Recommendation Report for Planning Permission for Works or Extension to a Dwelling

REF NO: WA/109/19/HH

LOCATION: 1 The Meadows
Walberton
BN18 0PB

PROPOSAL: New single storey side extension with mono-pitched roof.

title:
Proposed Plans

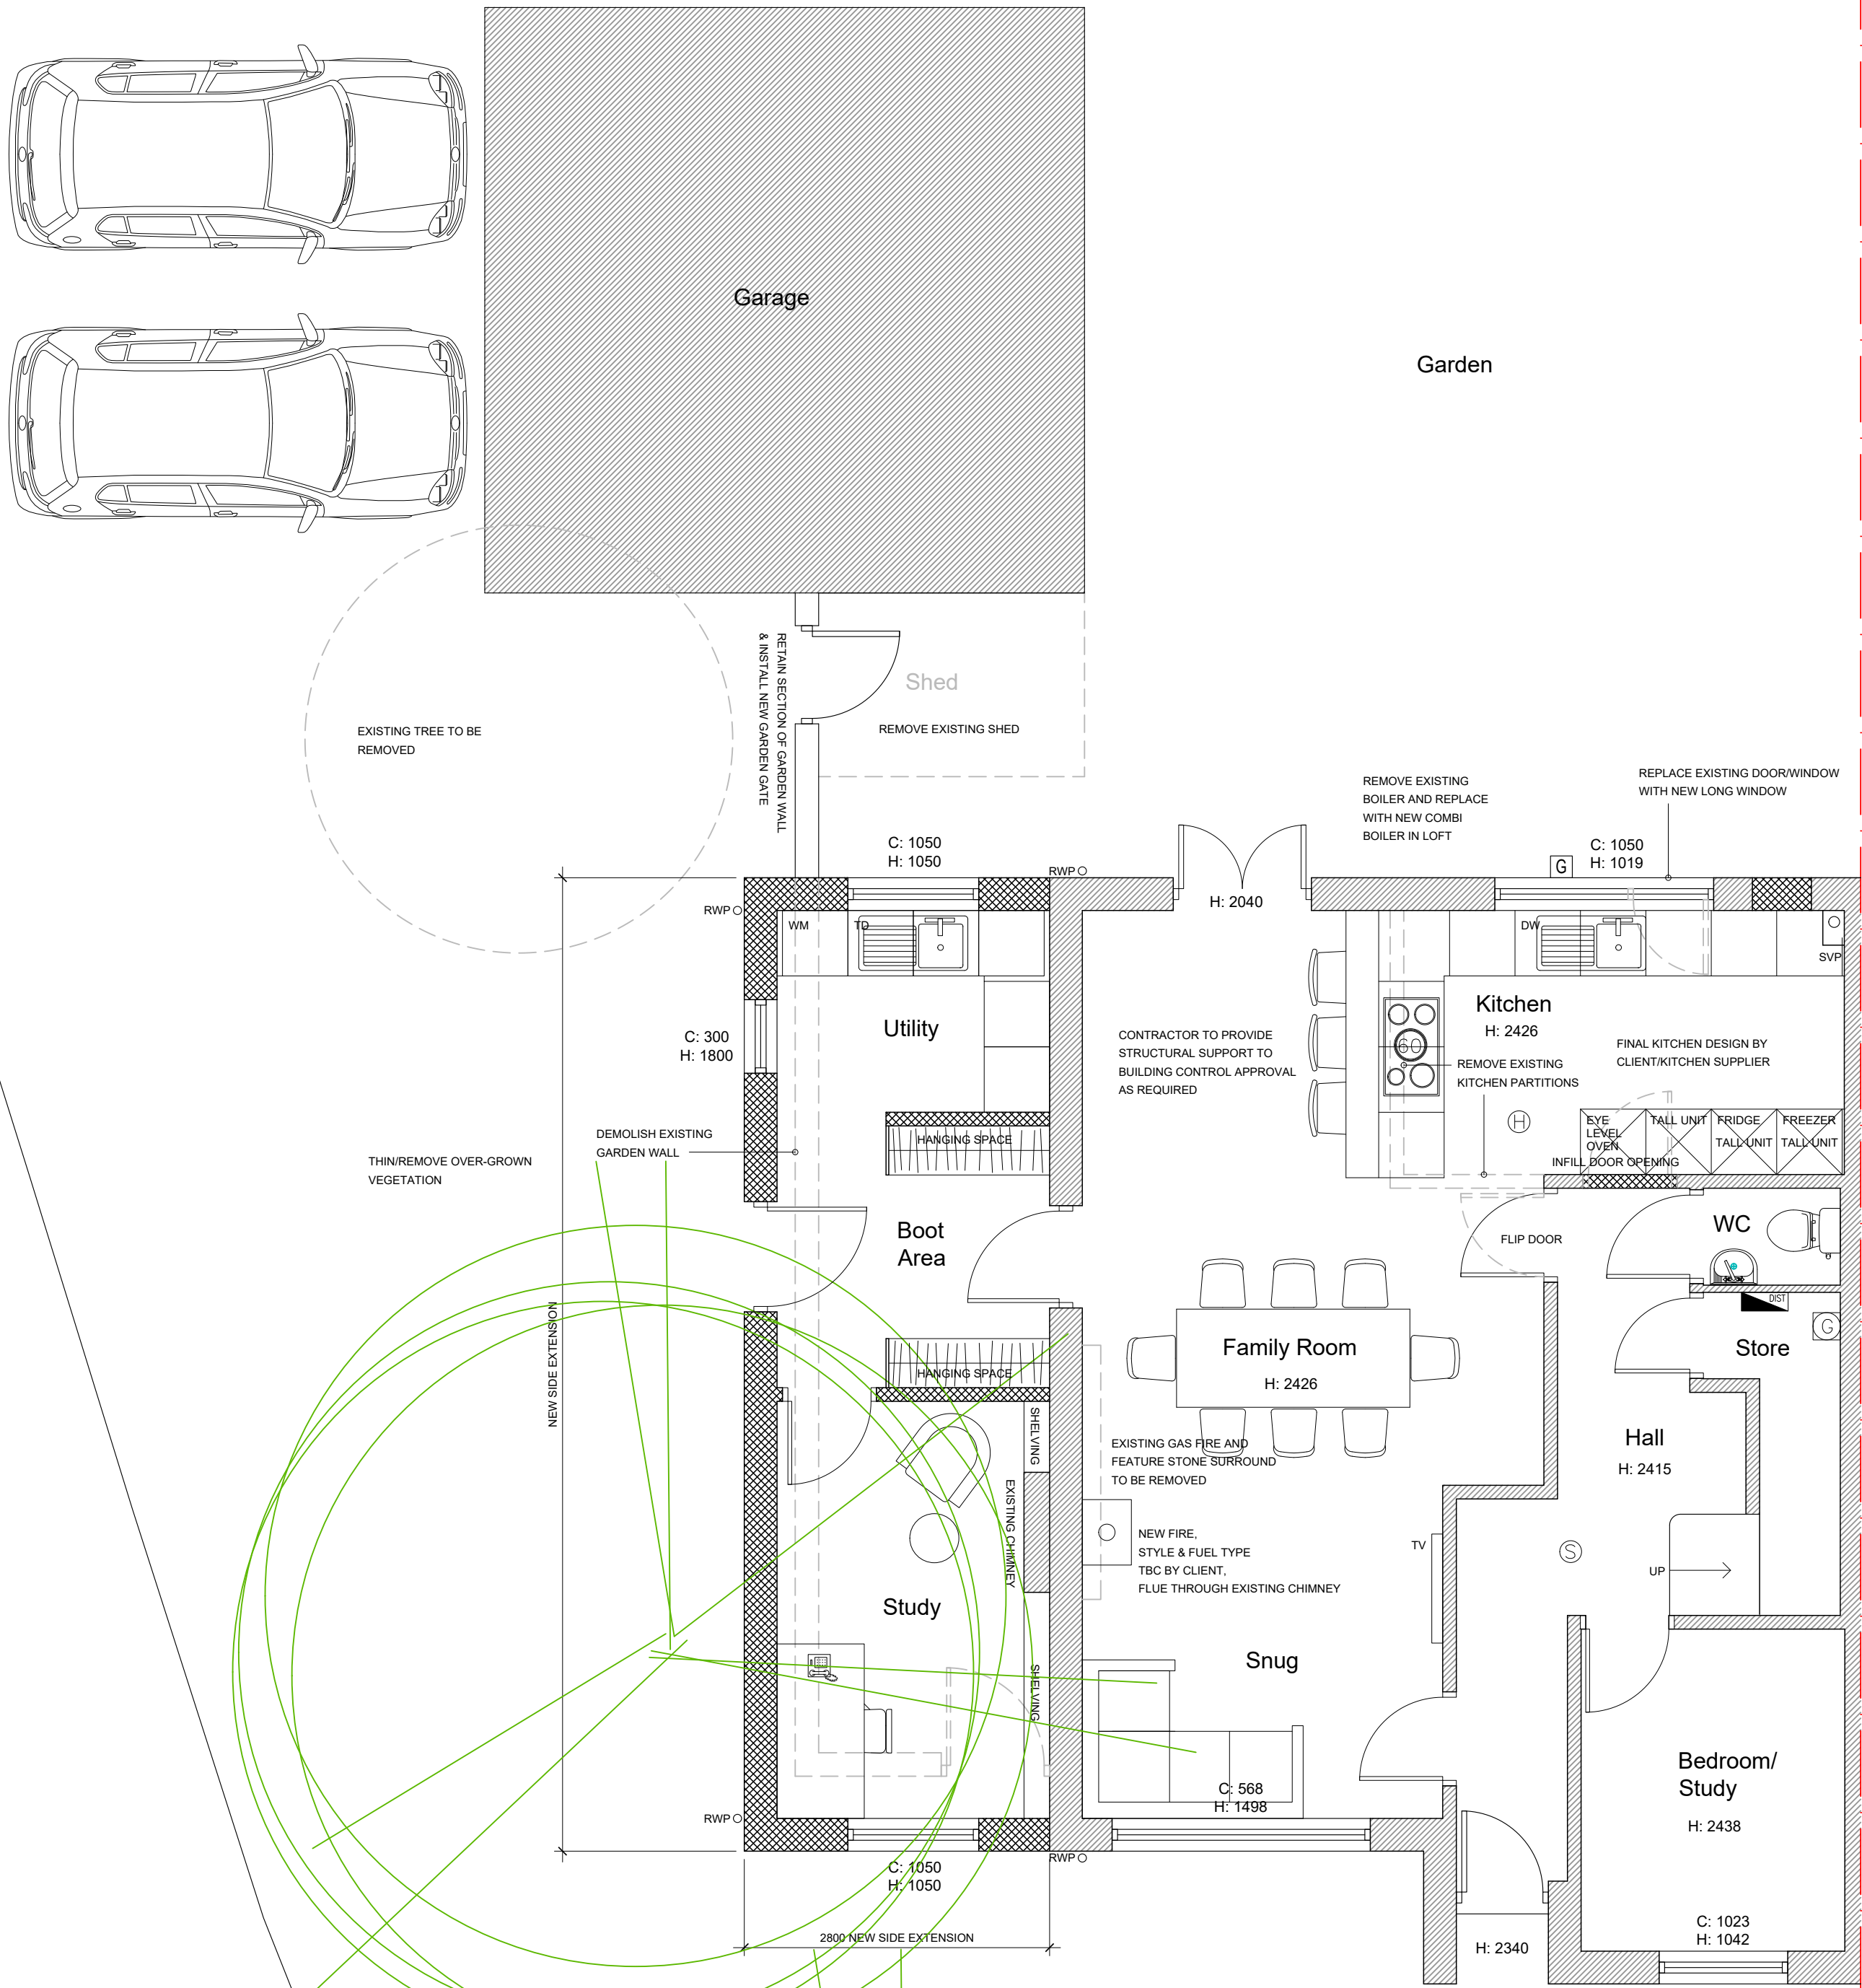
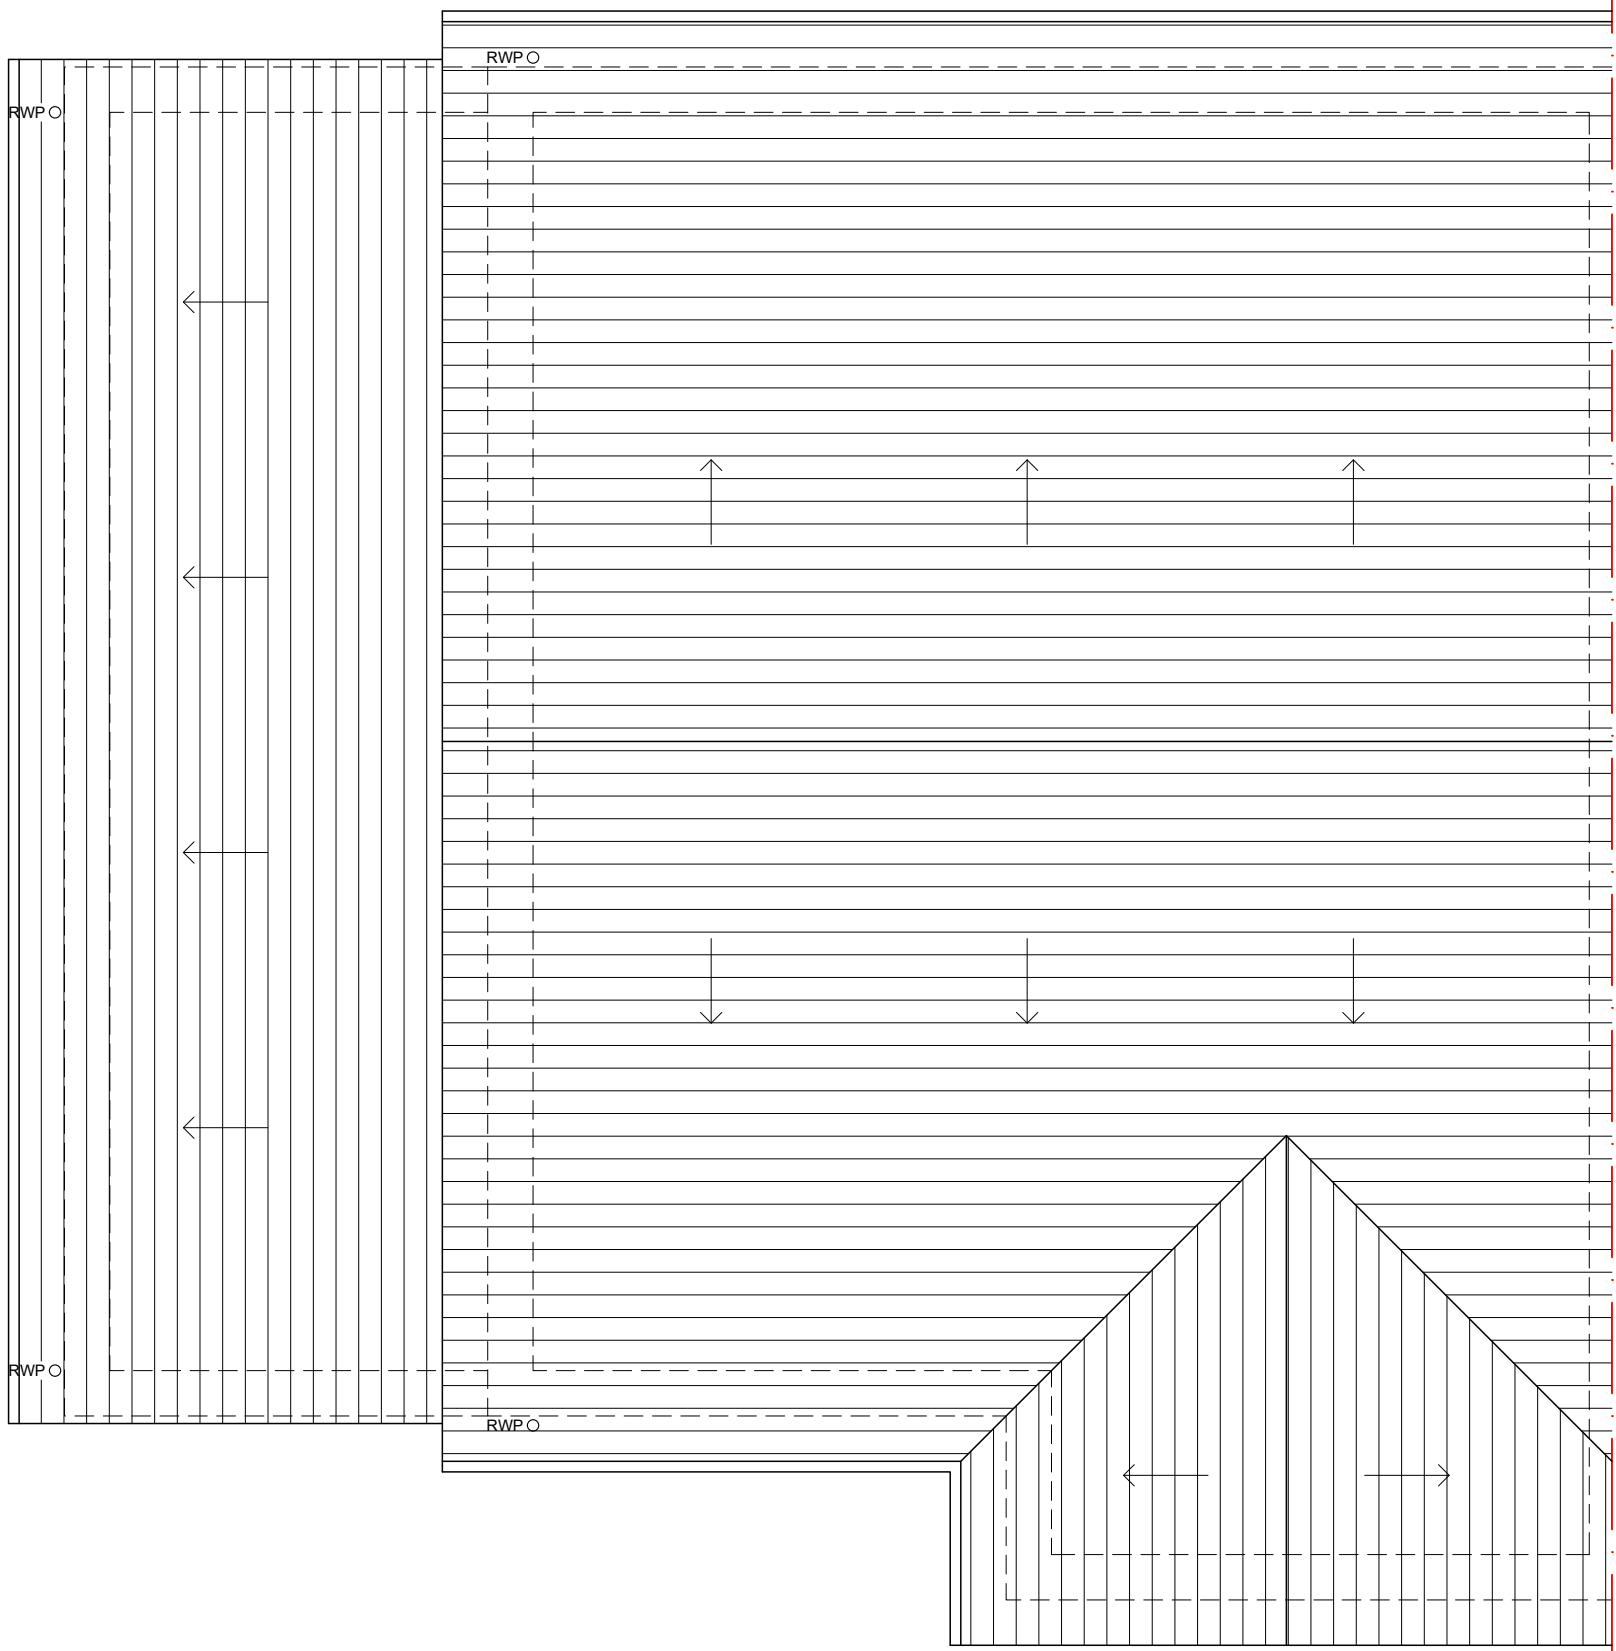
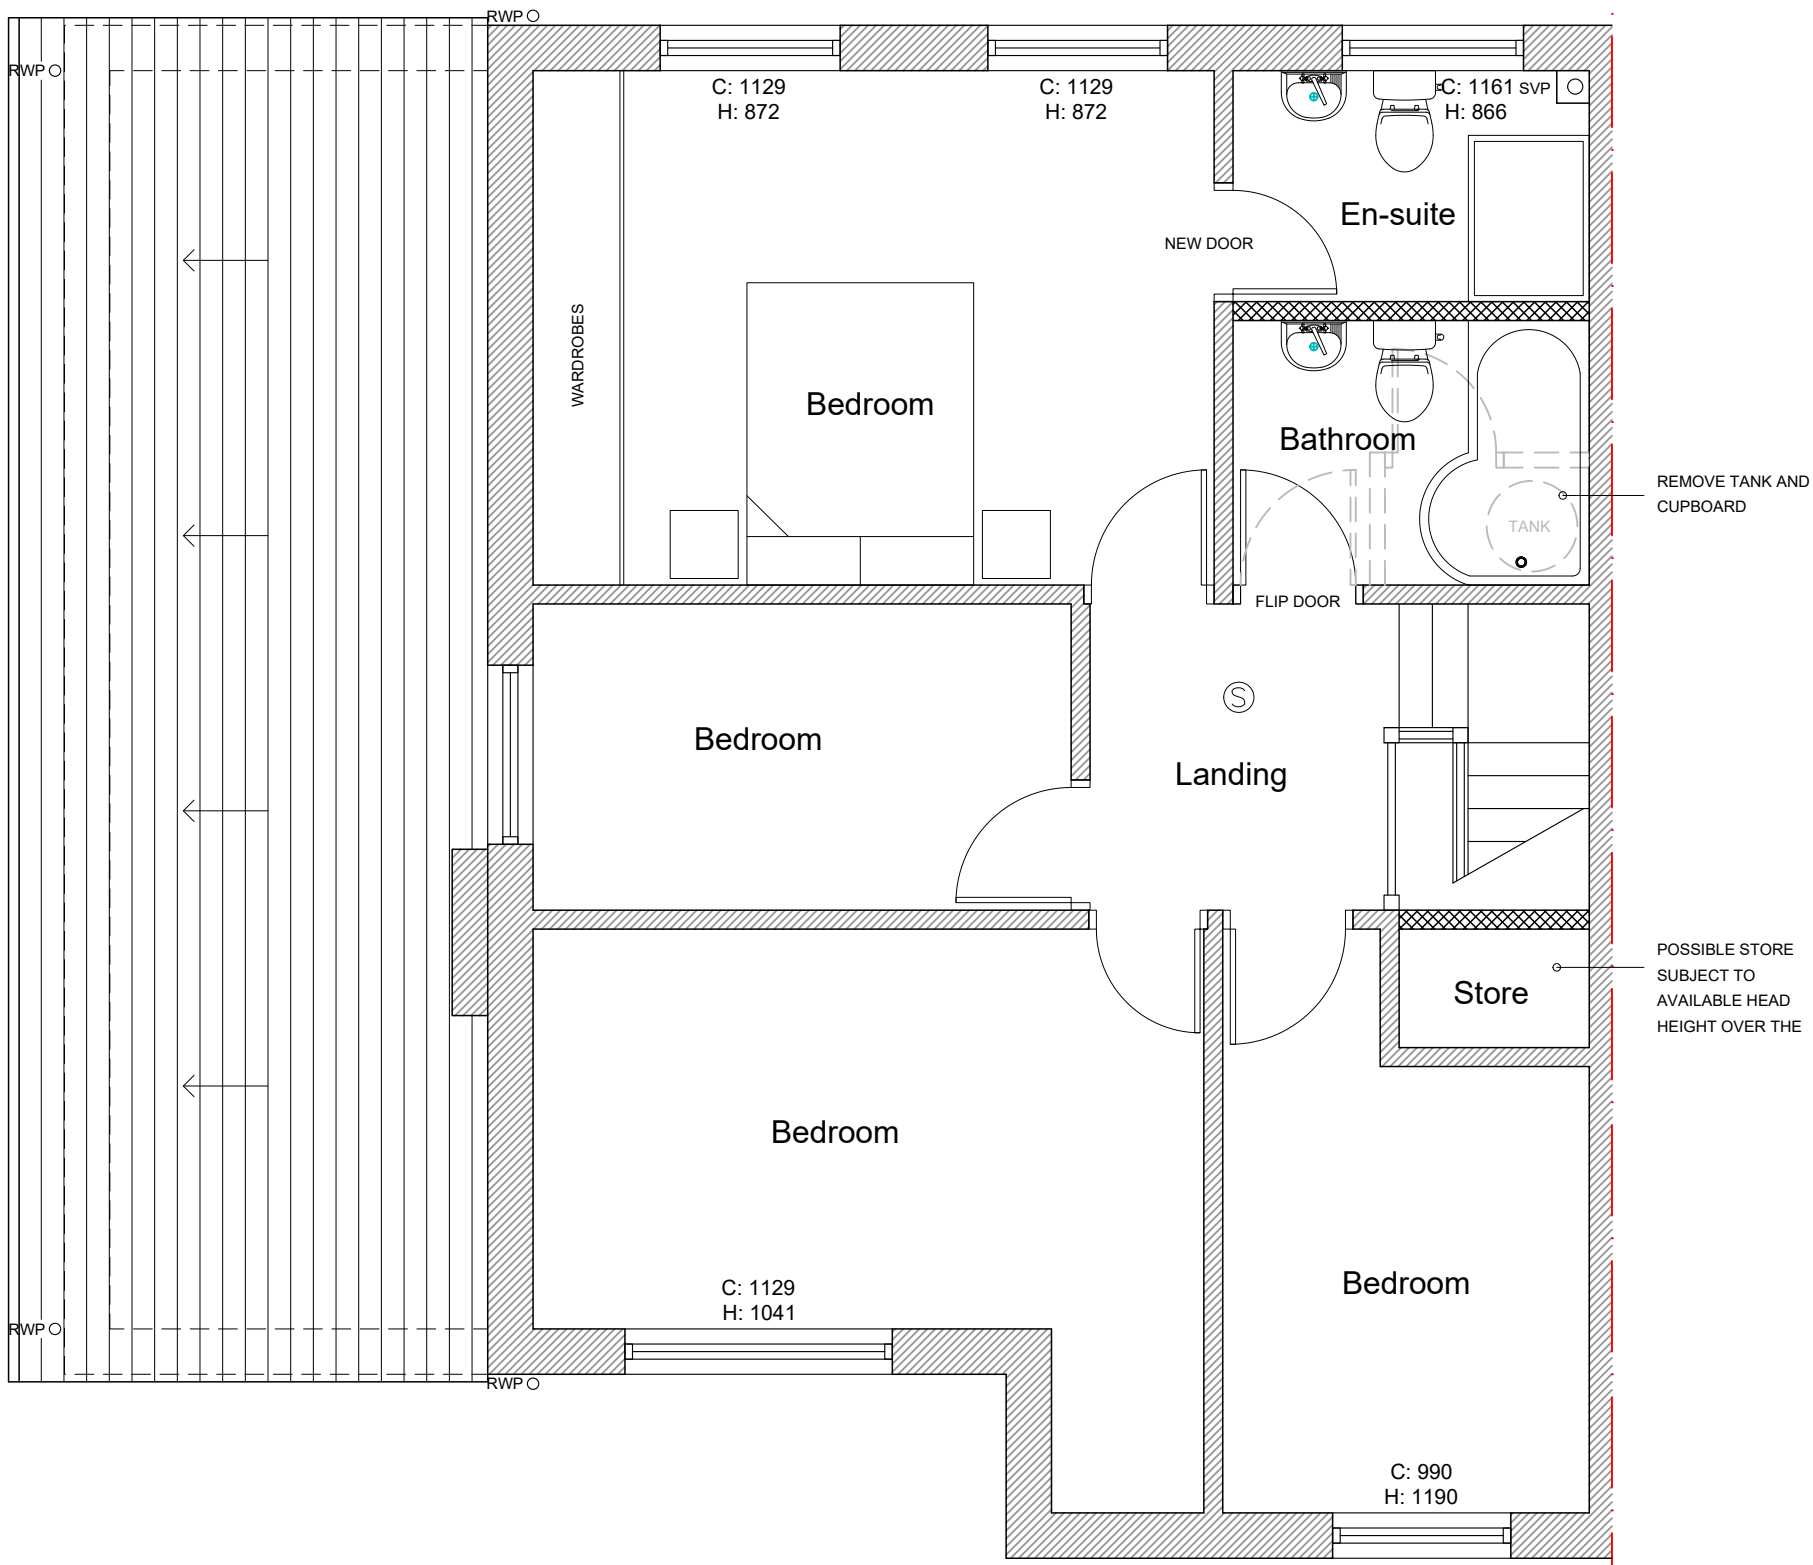
The proposed development is not considered to result in any significantly harmful overshadowing or overbearing impact upon the residential amenities of neighbouring dwellings. This is due to the siting of the proposal allowing a significant separation distance to neighbouring dwellings, therefore, mitigating any significantly harmful overshadowing. With regard to potential for loss of privacy to neighbouring dwellings, the single storey nature of the proposal is considered to cause the proposal to result in no views that are currently unavailable from the application site at current.
